Planning Consultation Memo

Date: 17 October 2023	Planning Officer: Elizabeth Mugova	Landscape/Tree Officer: Oliver Waring
Planning Application Number	<u>6/2023/0787/HOUSE</u>

Context	
Site Address	London Lodge Bedwell Park High Road Essendon Hatfield AL9 6HY
Relevant Constraints/Policies	<p>WHDP 2005</p> <p>R11 – Biodiversity and Development – all new development will be required to demonstrate how it would contribute positively to biodiversity of the site by retention and enhancement of the natural features on site.</p> <p>R17 – Trees, woodland and hedgerows – the council will seek the protection and retention of these features and require when appropriate new, native planting.</p> <p>D8 – Landscaping – the council will require the retention and enhancement of existing key landscape features (requiring detailed surveys)</p> <p>Policies from the local plan -</p> <p>SP11 – Protection and enhancement of critical environmental assets – protection, enhancement and management of the environmental, ecological and historical assets within the borough, will be sought commensurate with their status, significance and international, national and/ or local importance.</p> <p>SP12 – Strategic

1 Site Location Plan - London Lodge - Proposed
Scale: 1:200

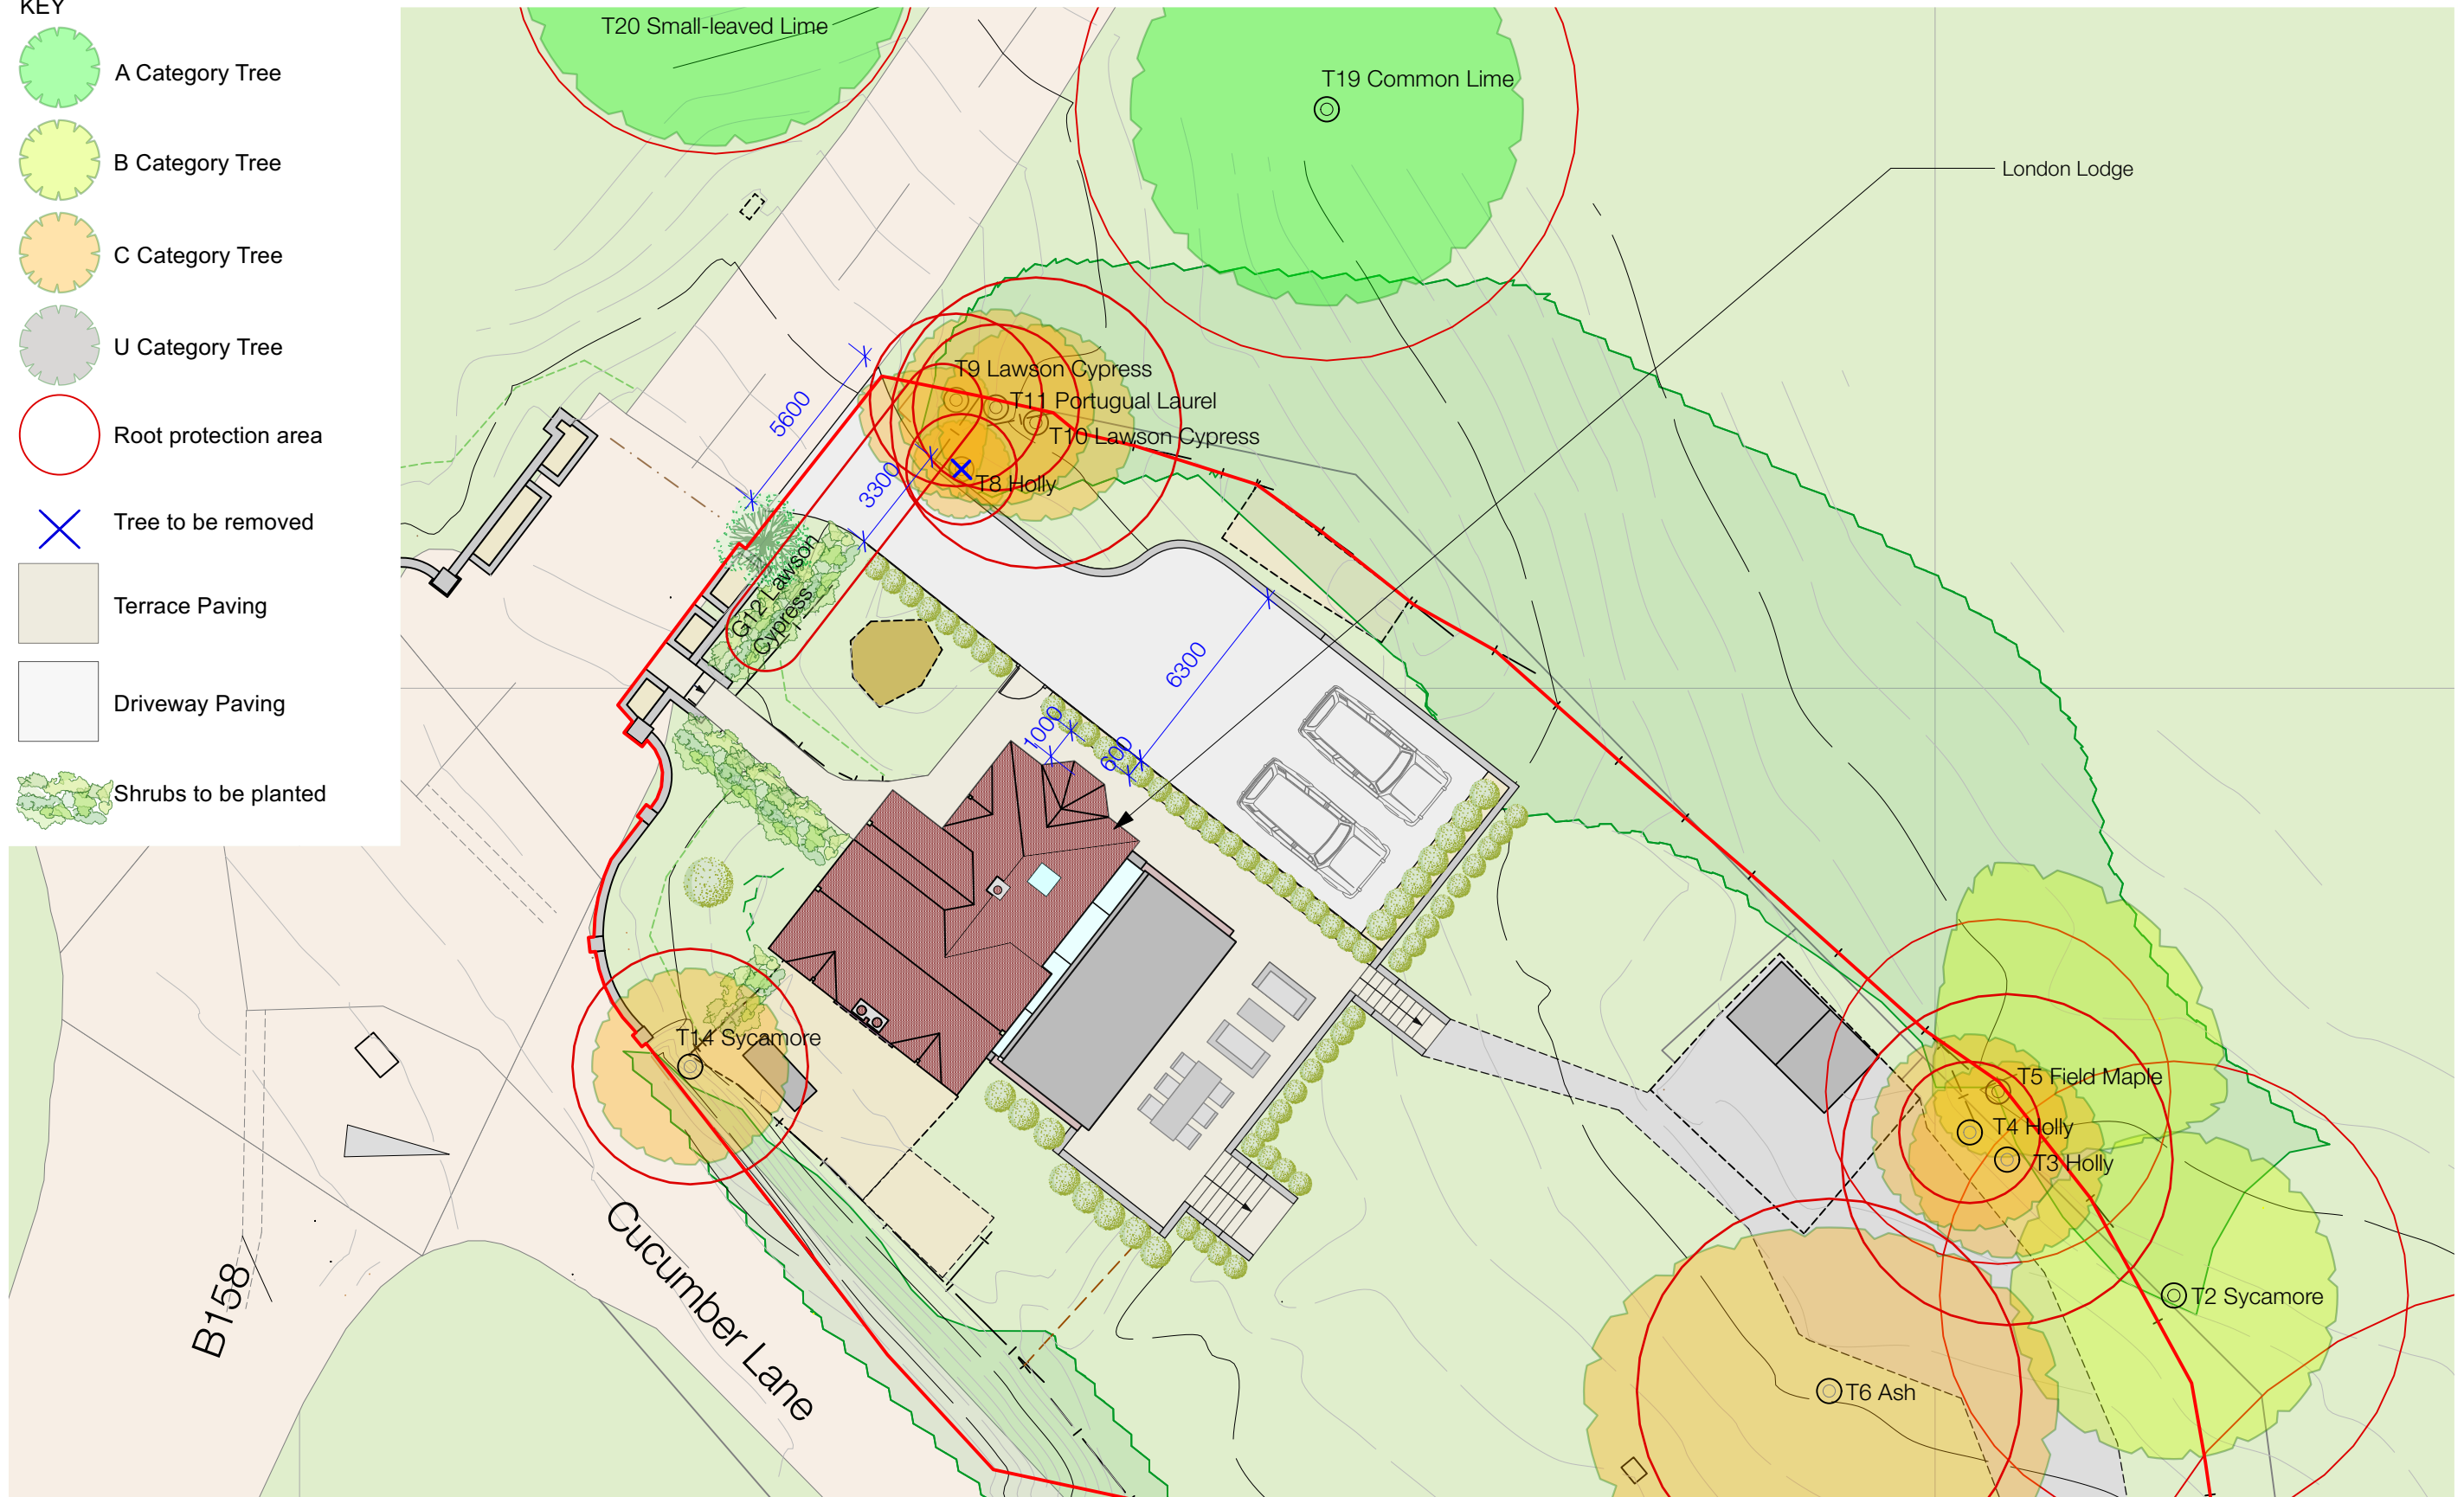
Comment: The proposal requires the removal of a Holly (T8) and group of Lawson Cypress (G12) managed as a hedge.

<p>Would the development maintain the amenity of adjoining occupiers? (e.g. privacy, outlook, light etc.)</p> <p><input type="checkbox"/> Yes <input checked="" type="checkbox"/> No</p> <p>Comment (if applicable):</p>
<p>Is there a detailed proposed landscape plan?</p> <p><input type="checkbox"/> Yes <input checked="" type="checkbox"/> No <input type="checkbox"/> N/A</p> <p>Comment (if applicable): Some indicative landscaping is shown proposed site layout, but no detail has been provided.</p> <p>It is recommended that landscaping details are requested via condition should the application be approved.</p>
<p>Recommendations and conclusion</p> <p>The proposal will have a limited affect in the landscape in the area. There is no objection to the proposal on landscape grounds with the proviso that appropriate landscaping is provided as part of the development. If approved, it is recommended that the following be requested via condition prior to any on site activity:</p> <ul style="list-style-type: none"> • A detailed landscape plan to include plant species, plant sizes, planning densities (where applicable), planting methods and aftercare. • The proposals should include the planting of at least one tree to mitigate the tree losses on site.
